**Your Ref:** OWPC22823  
**Our Ref:** CM/18/19/PL 04-04-2019  
**Please ask for:**  
Zac Denton

Erection of 2 No 3 bed dwellings with off-road parking and associated landscaping  
Land at Entrance to Waterford Gardens Horsemere Green Lane Climping

Thank you for your internet representation made on 8th May 2019 which has been recorded as '**no objection**' with the comments as follows:

drawing title:
Site Plan

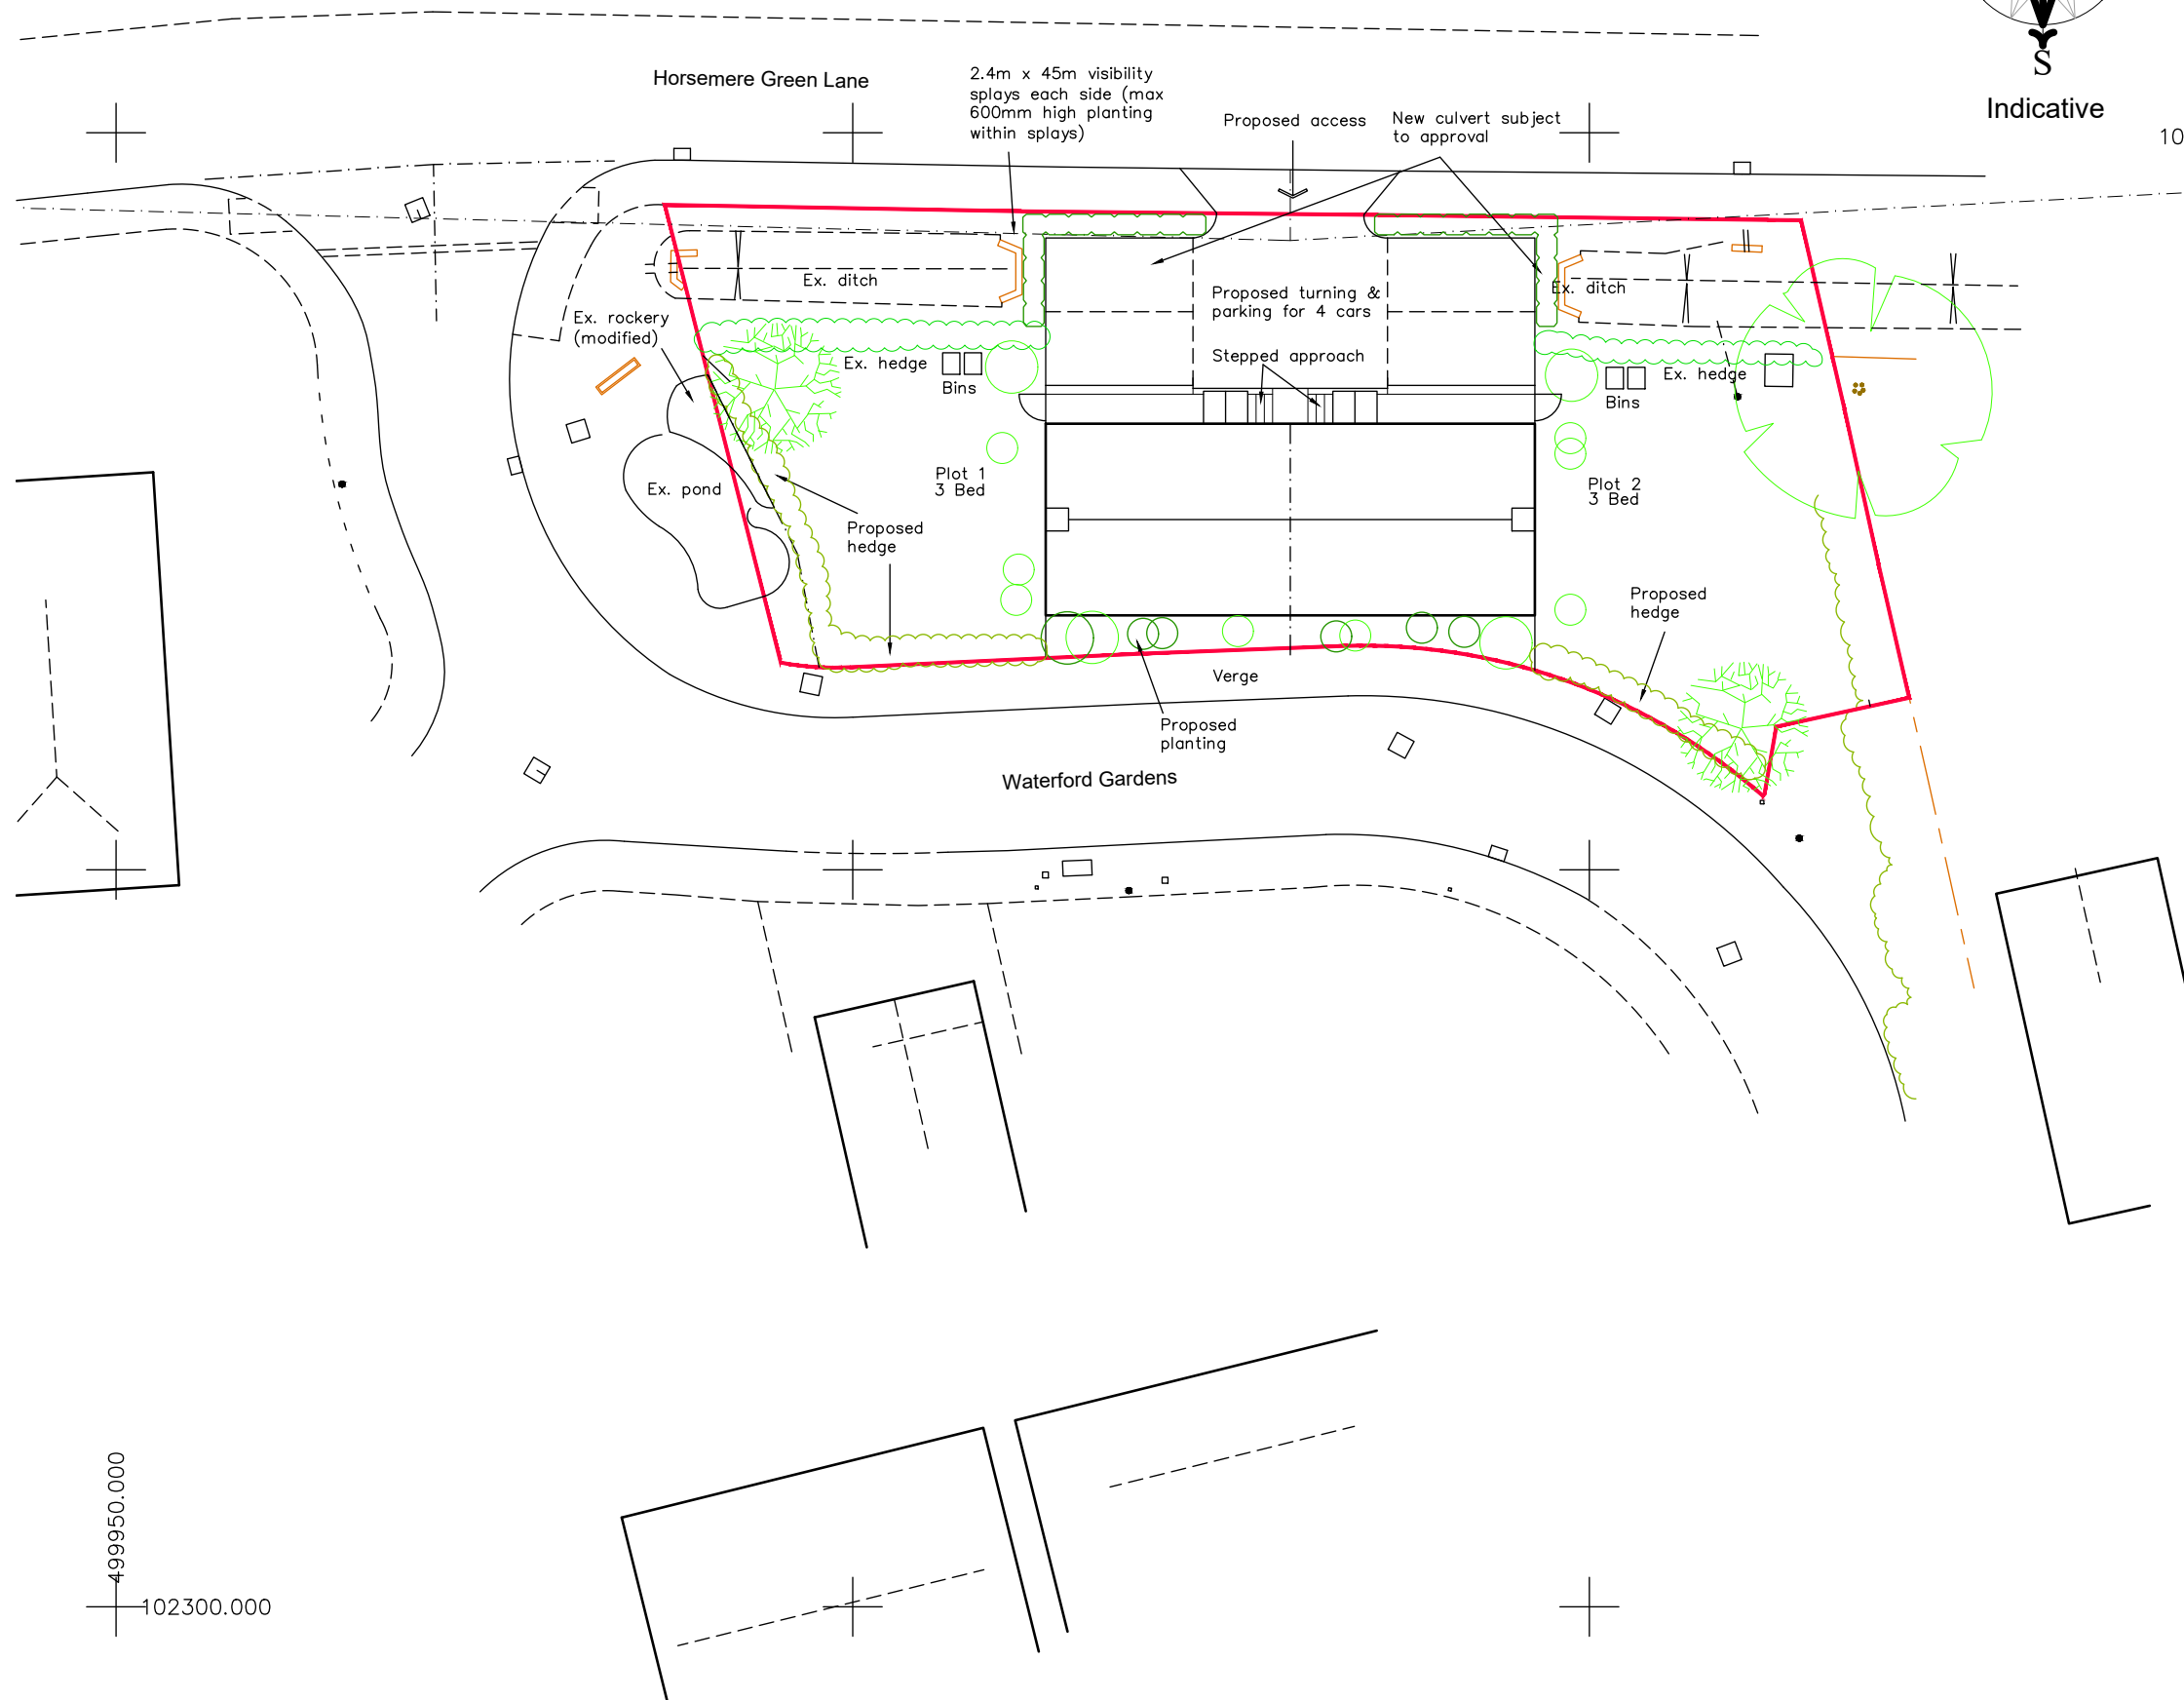
*I have mixed feelings about this new application. In principle the existing consent for a single detached house is more appropriate for the location within Waterford Gardens. But the highways access from Horsemere Green Lane now proposed is much better from an estate management point of view as the roads on the estate are in private ownership. The block plan appears to show the site infringing on the existing pond and landscaped area which are now in the ownership of the estate, so this needs rectifying.*

Proposed Elevations

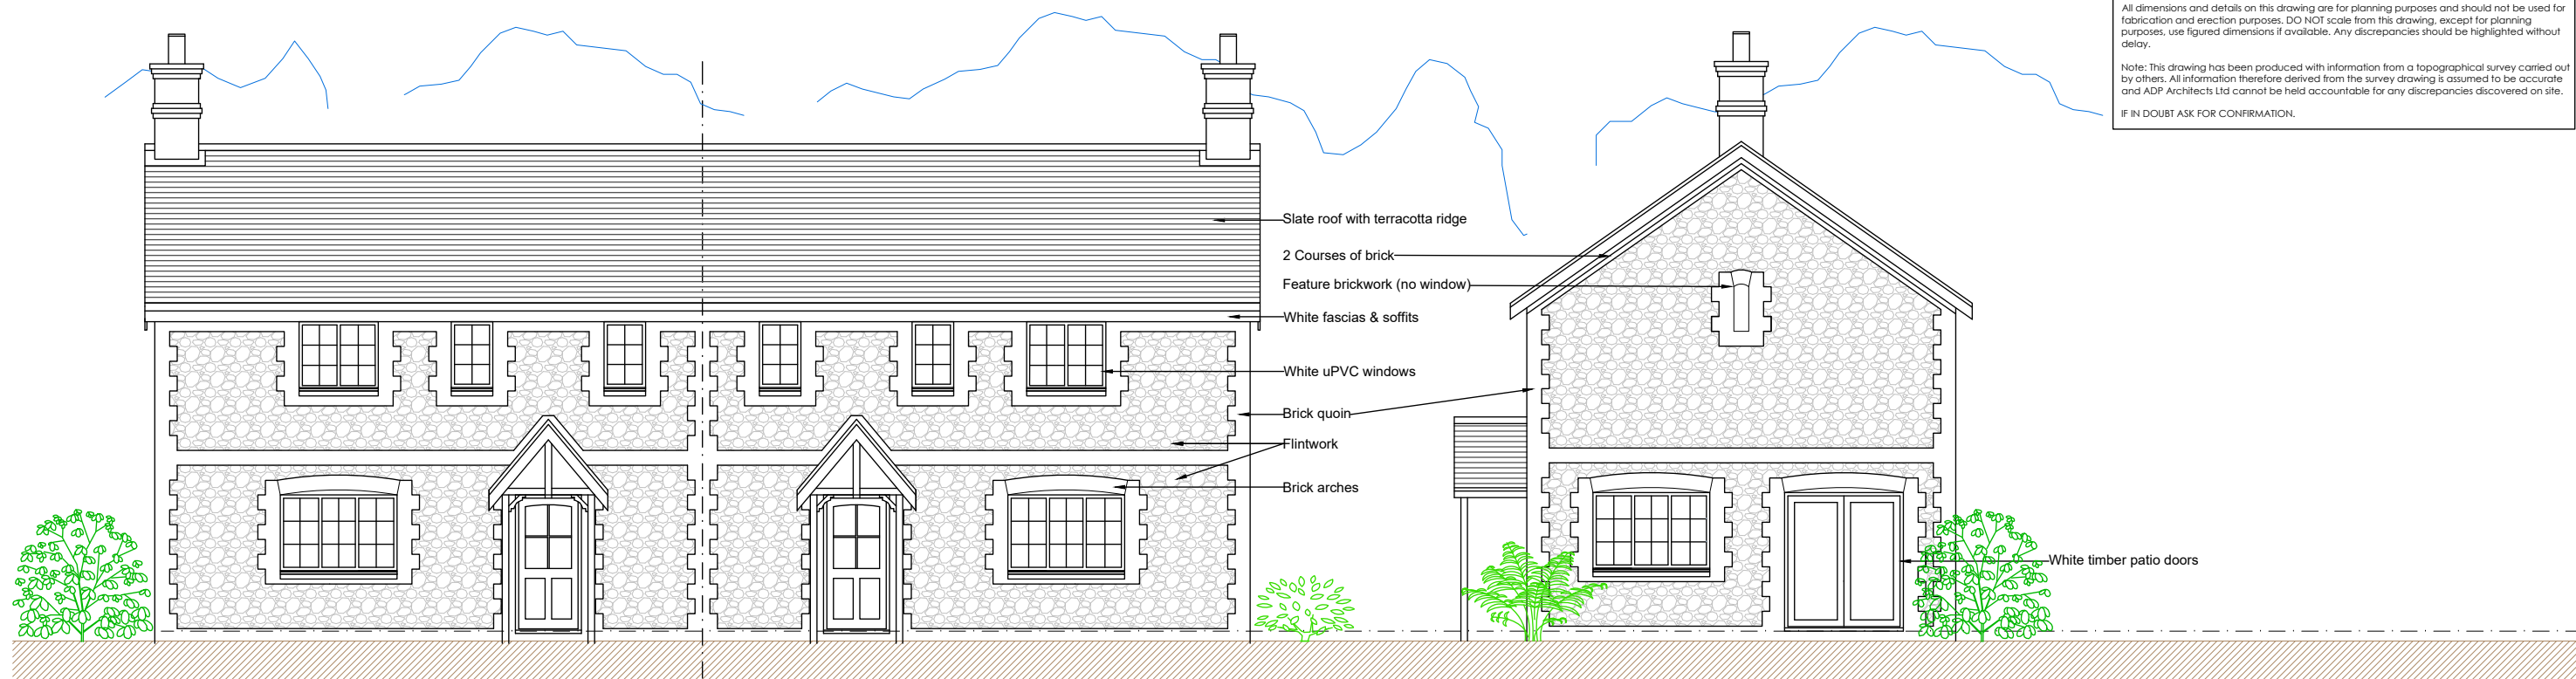
*It is difficult to make specific observations at this stage as no elevations have been provided so we need to see these first. The design of the buildings must complement and enhance the existing buildings on this development. These are all traditional in design. All the other semi detached houses on the estate have thatched roofs so this one should too. There needs to be planning conditions that ensure:*
